Subject: Modification Part 3A CiviLake Construction and Green Waste Recycling Project

Lake Macquarie City Council Response to Modification

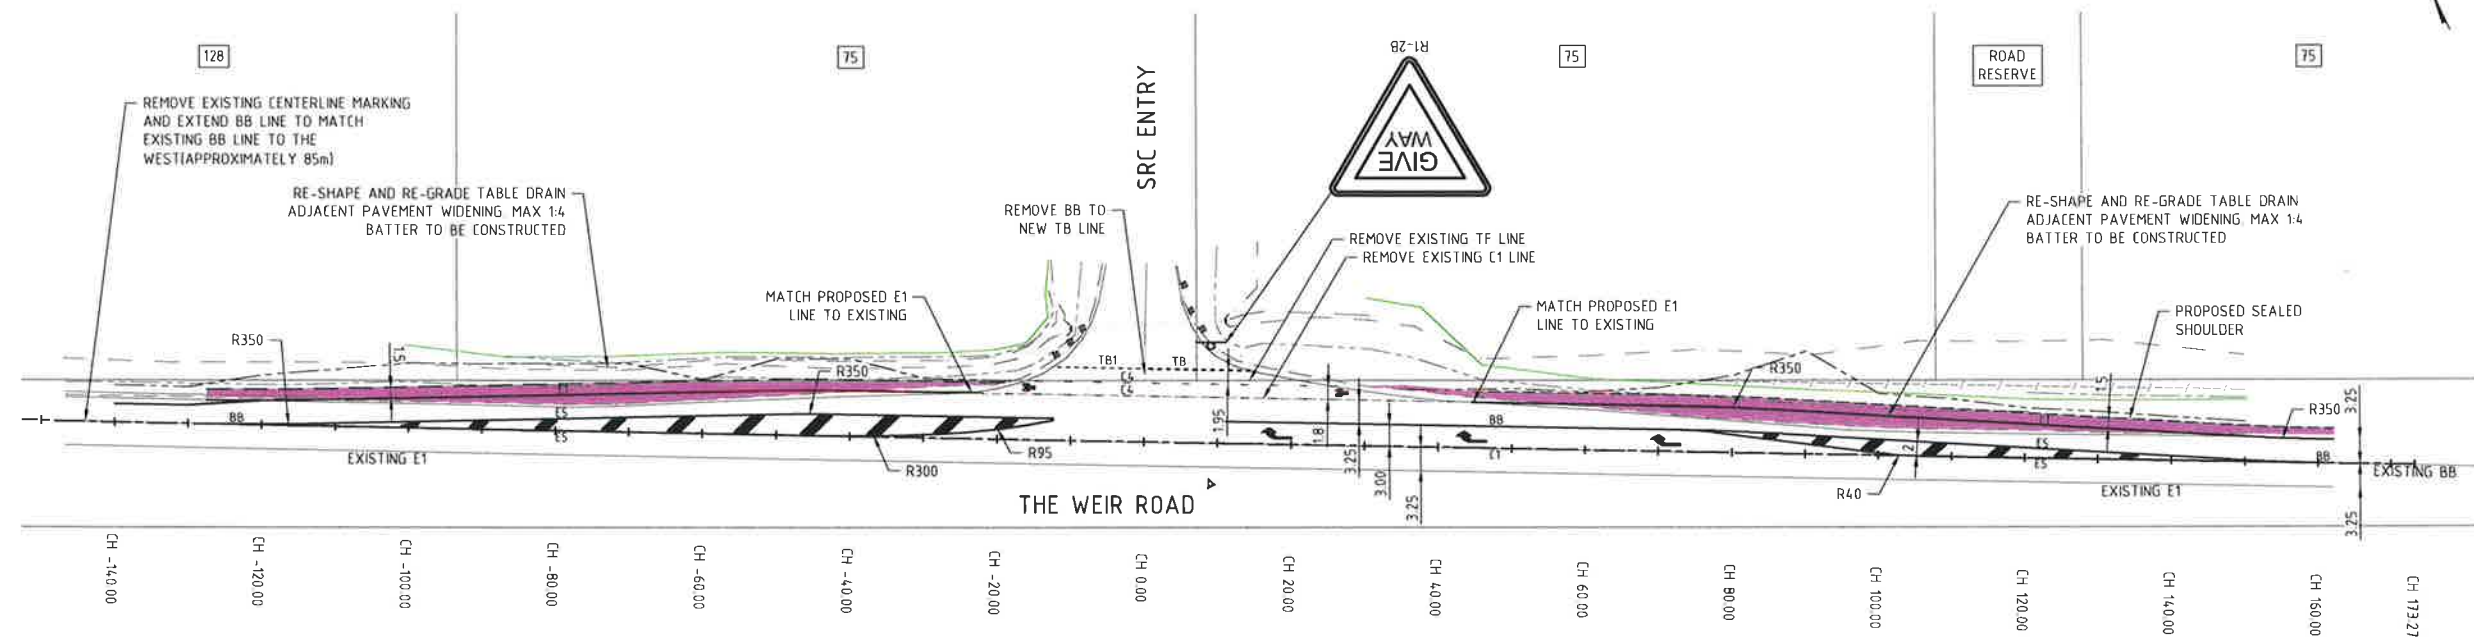
Road Design – The proposed channelised right turn (CHR) intersection treatment is supported. Intersection plans presented, have been endorsed by the Traffic Facilities and Road Safety Committee and approved by Council in March 2019.
